Application by RWE Renewables UK Solar and Storage Limited for Tween Bridge Solar Farm Project

The Examining Authority's written questions and requests for information (ExQ2): Issued on 07 July 2026

Coordinate System: British National Grid
 Projection: Transverse Mercator
 Datum: OSGB 1936
 Scale: 1:20,000
 Paper Size: A3
 © Crown copyright and
 Ordnance Survey 2023
 Licence: AC000008122
 Overview Sheet

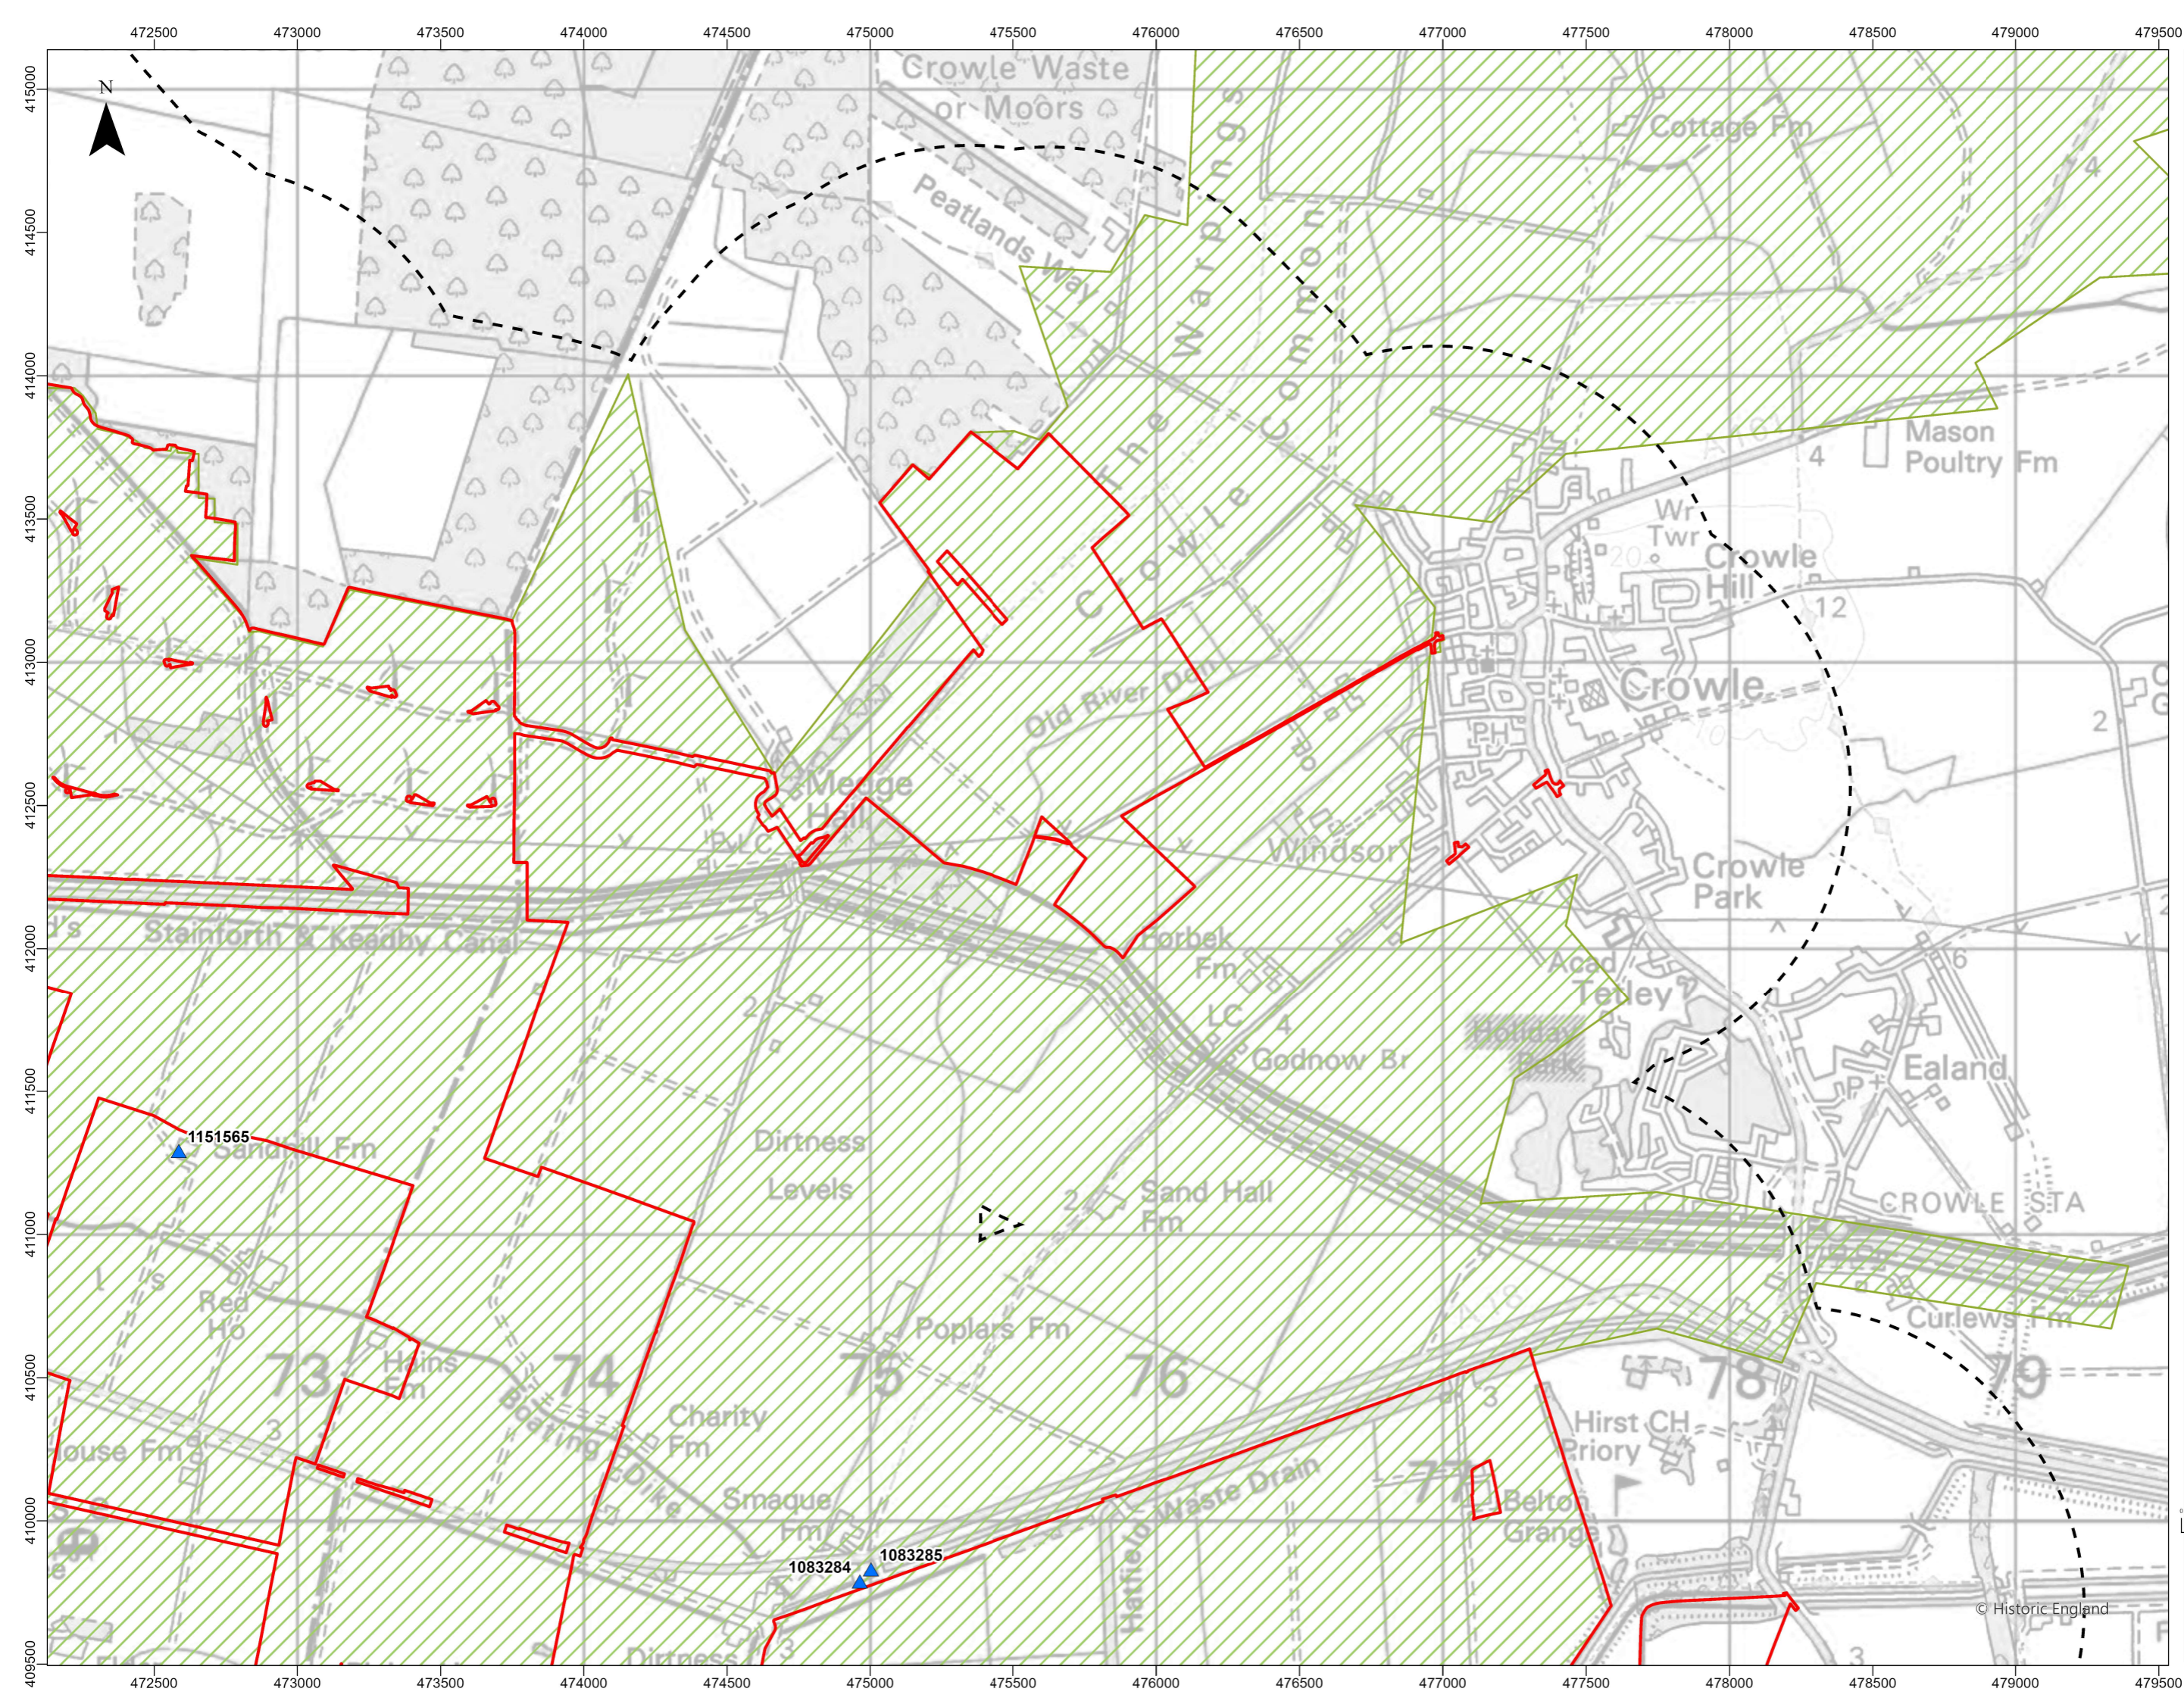
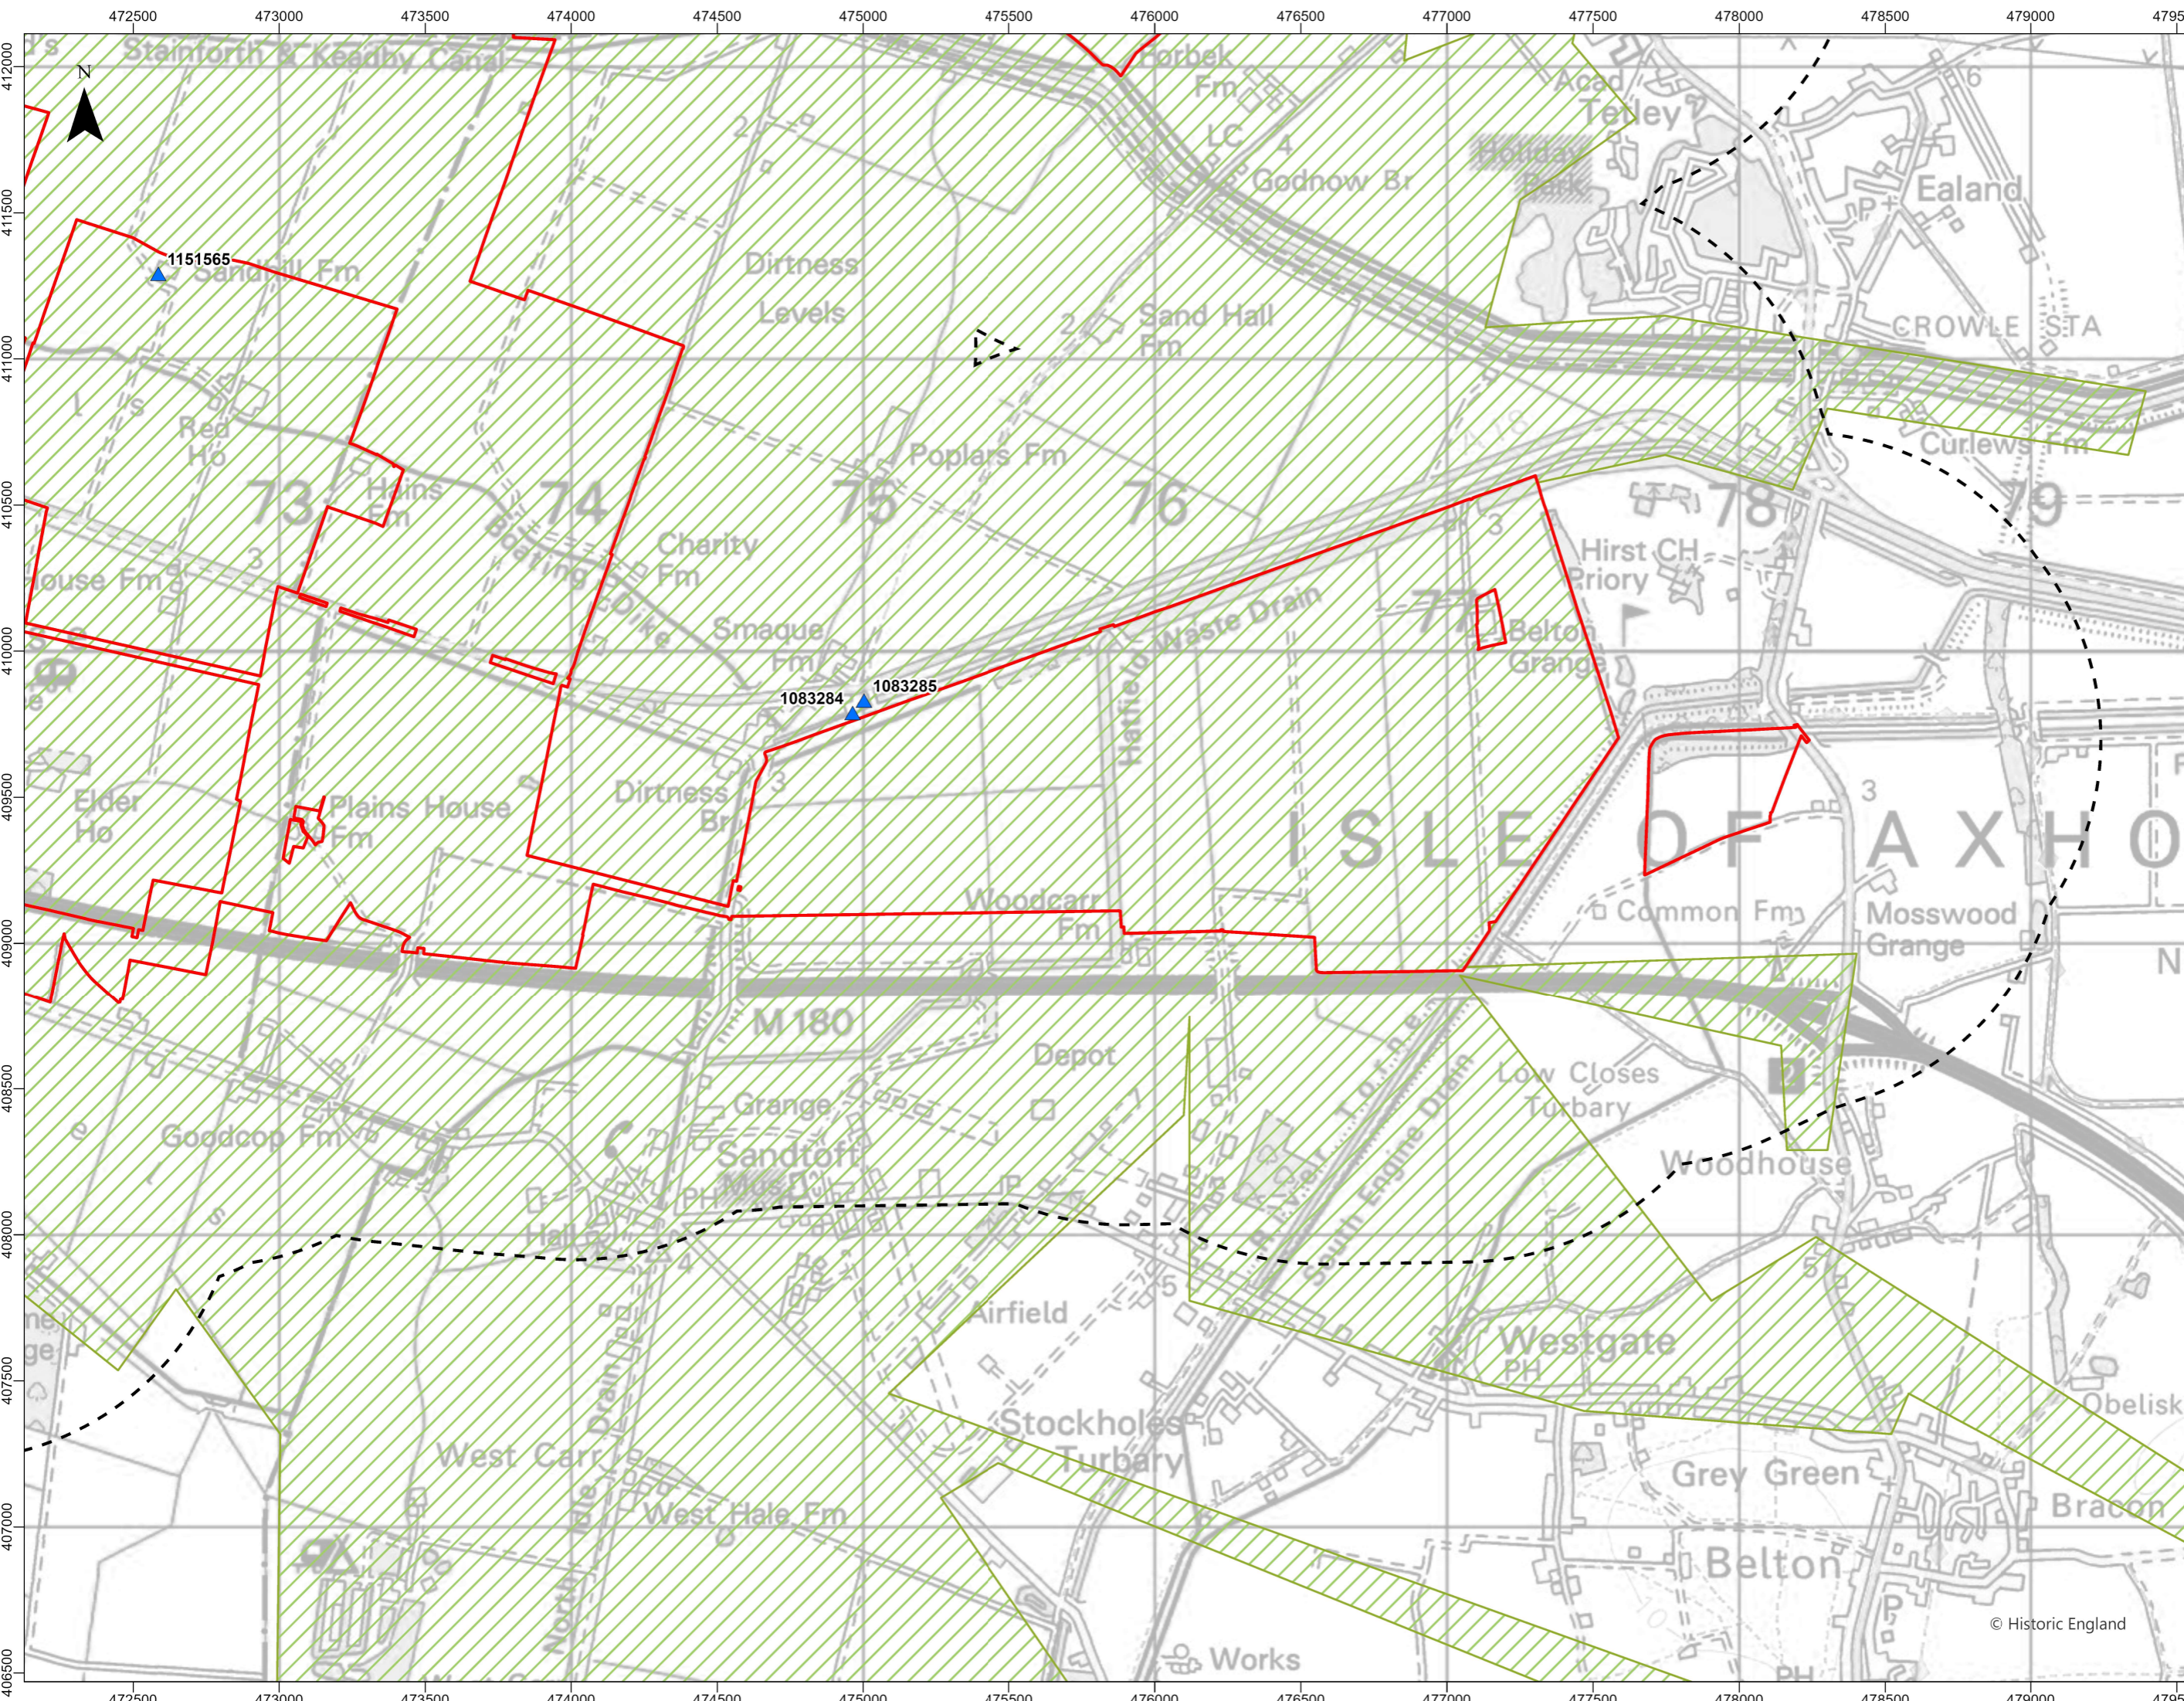
Q2.6.8	Applicant	Heritage assets The applicant's response to EXQ1 6.0.3 [REP2-087] states in part: "The Applicant has revised Figure 1 in ES Appendix 8.1 Heritage Baseline Assessment Document Reference 6.3.8 Revision 2] to show all of the designated heritage assets within the SZTV or 1km buffer around the Order Limits". However, there appear to be some heritage assets located north of Sandtoft and south of the M180 which are within 1km of the order limits. There also appear to be an even larger number which are located within the ZTV (in Sandtoft for example). These are not shown on the figure and should be. They should also be assessed accordingly.
Q2.6.9	Applicant	Q6.0.10 The applicant has provided a response to EXQ1 Q6.0.10 [REP2-087]. However, could the applicant update the ES to include this explanation?
Q2.6.10	Applicant	Archaeology CDC's response to written question 6.0.7 [REP2-099] states in part: "Magnetometry has been relied on as the main evaluation technique but the influence of the alluvial deposits on the effectiveness of the geophysical survey technique has not been resolved. The applicants contend that the survey was targeted at understanding near surface archaeological remains- "Magnetometry was not intended for consideration of deep deposits" (APP-045 ES Ch 8. Table 8-3: Summary of Consultation)- and the geoarchaeological desk-based assessment is the only site wide consideration of the potential for deeply buried remains. In addition, the effectiveness of the geophysical survey in identifying near surface archaeological remains is uncertain. Cropmark data indicated Romano-British activity in the Sandtoft area. Area 3 of the trial trench evaluation targeted this area identifying a Romano-British settlement dated to the 2nd/ 3rd century recording features consistent with the cropmark evidence. Despite only being covered by, on average, 30cm-50cm of topsoil and subsoil, none of the features associated with this settlement were recorded as anomalies by the
